From: Paul Wright [REDACTED]
Sent: 20 December 2018 12:29
To: Stuart Corbey
Subject: RE: 2 Pagham Road, P/99/18/HH

Subject: 2 Pagham Road, P/99/18/HH

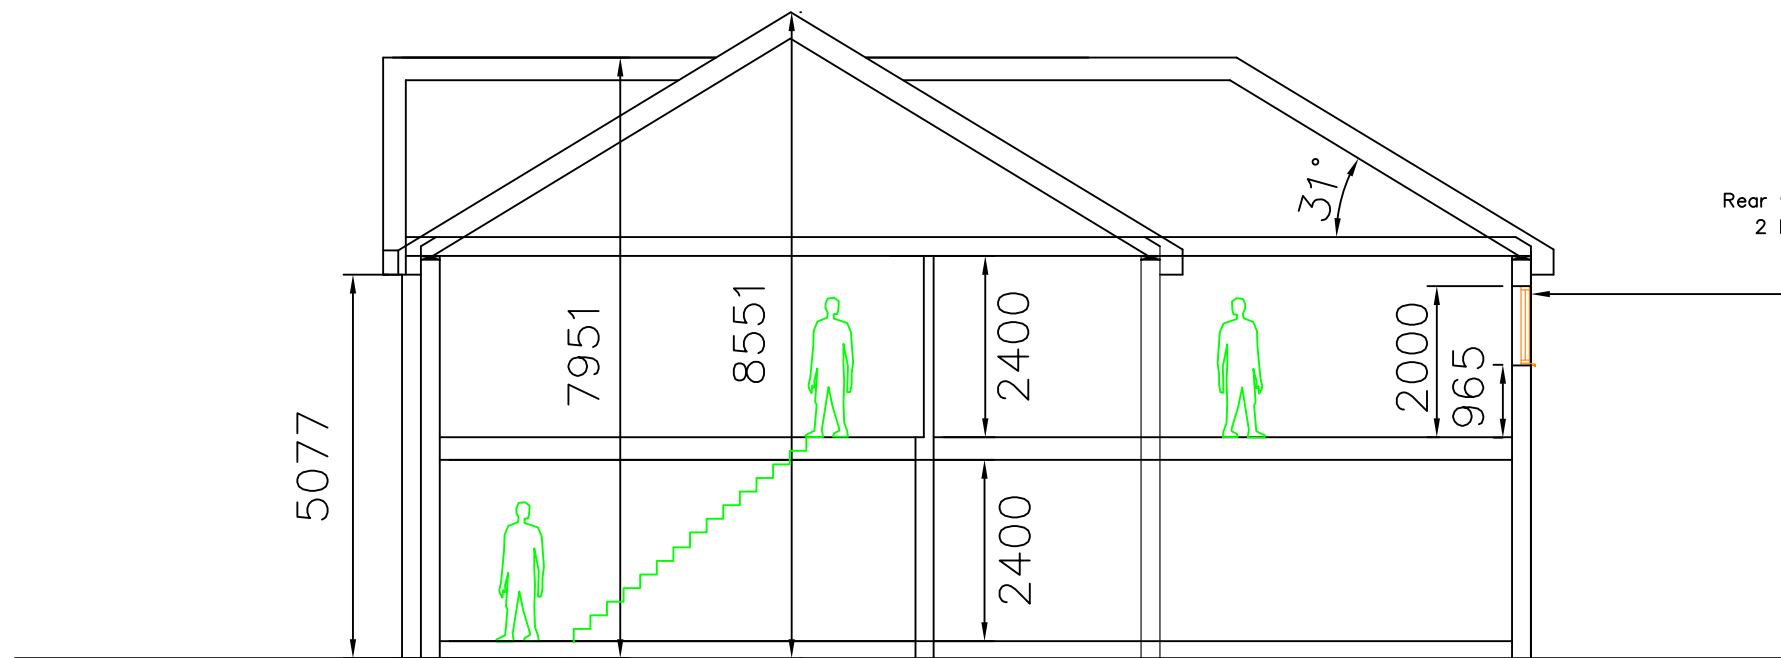
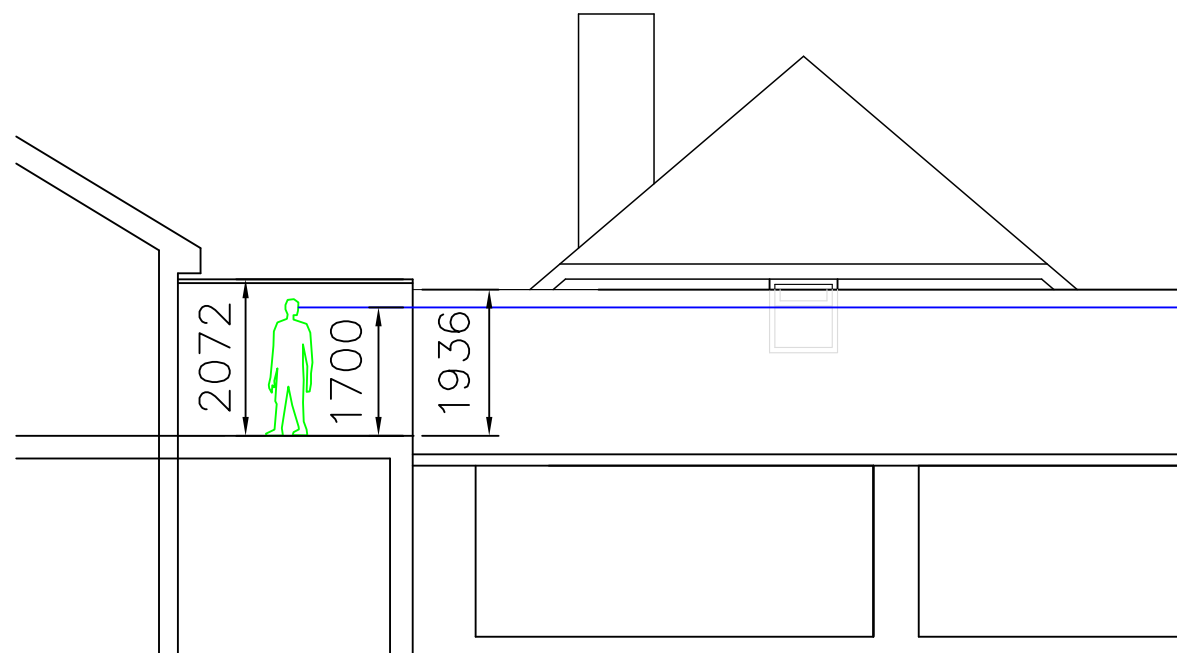
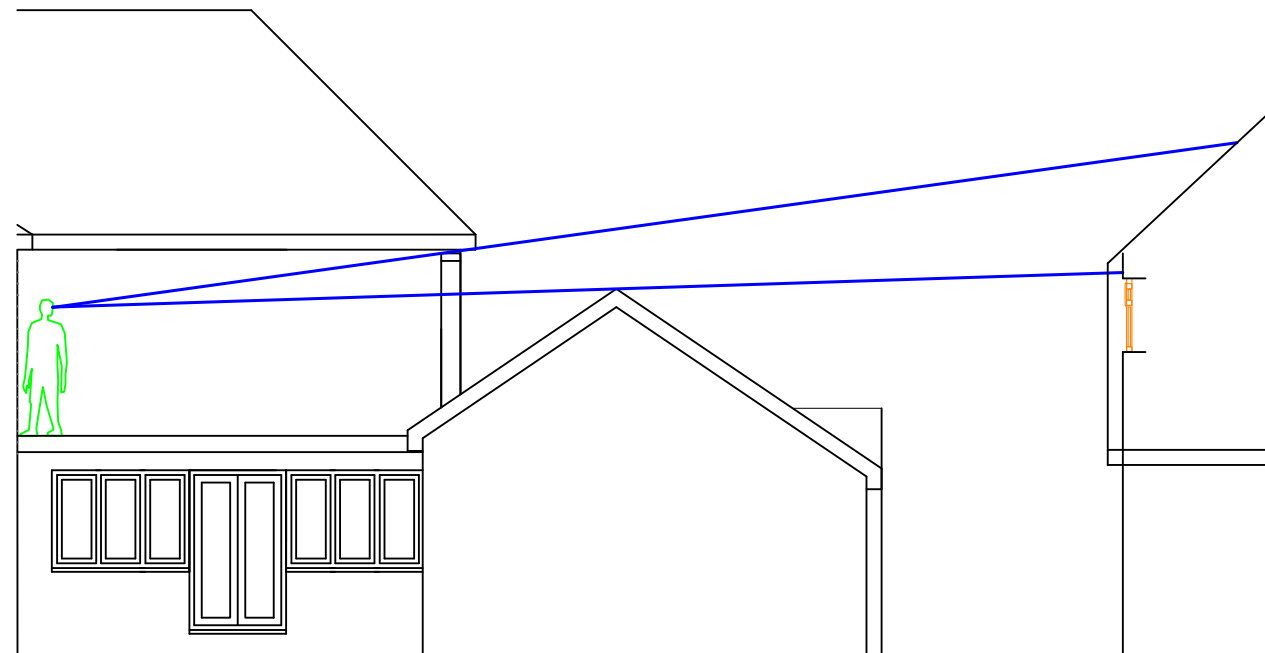
What would be helpful is a cross section and elevation of the proposed development inclusive of the site arrangement with the existing outbuilding (dotted line) in addition to extant permission under P/18/03. This level of plan would make the situation more clear and assist with the assessment.

I am not sure what more detail I can provide to the cross-section P006_B so please could you give me a call to explain what exactly you require, and I will get this done immediately. I have left you a voicemail also this morning.
